PLANNING CONSULTATION RESPONSE

Application No	2026/0612
Proposal	2026 0612 New Café Bar & Retail Eldon St Main Stairwell Reinstatement, Music Venue and Associated Works Civic Hall Eldon Street
Address	Civic Hall Eldon Street
Date of Consultation Reply	120826
Consultee	Tony Wiles Senior Conservation Officer

Drawing Title
2F GA Existing

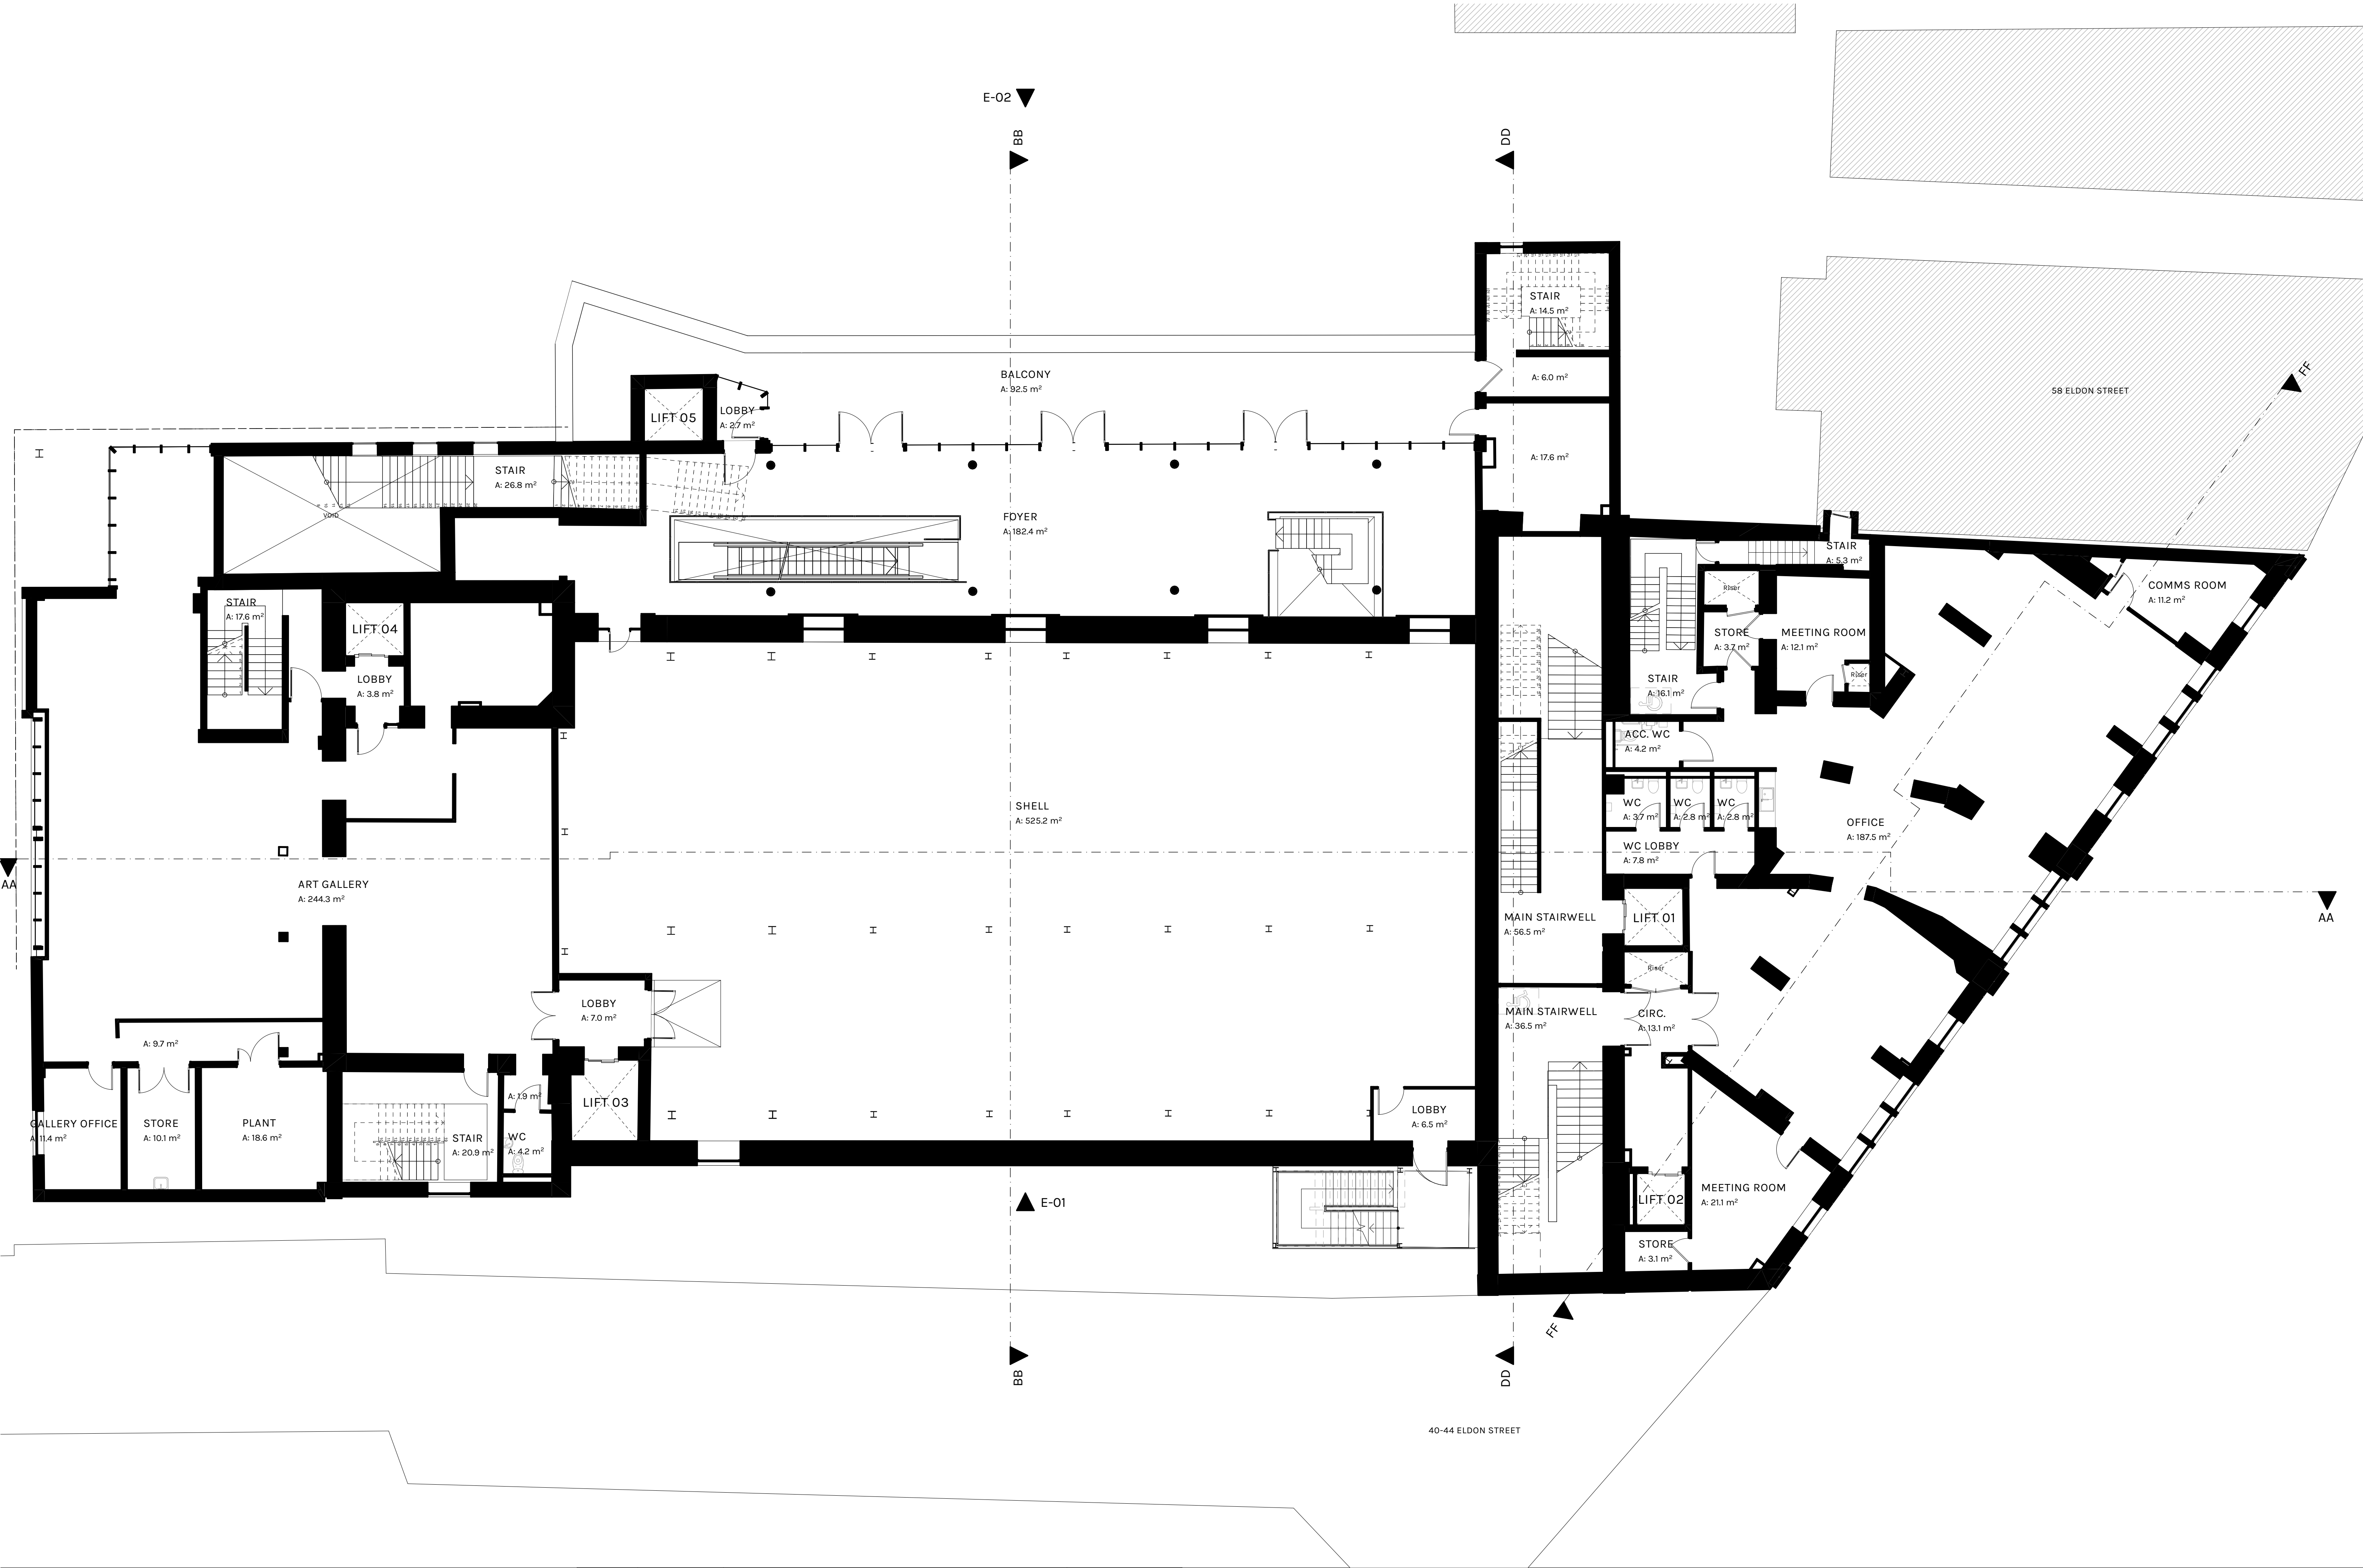
No works other than already noted removal of the modern partition wall north of the southern stairwell (P1-GF-SW-01)
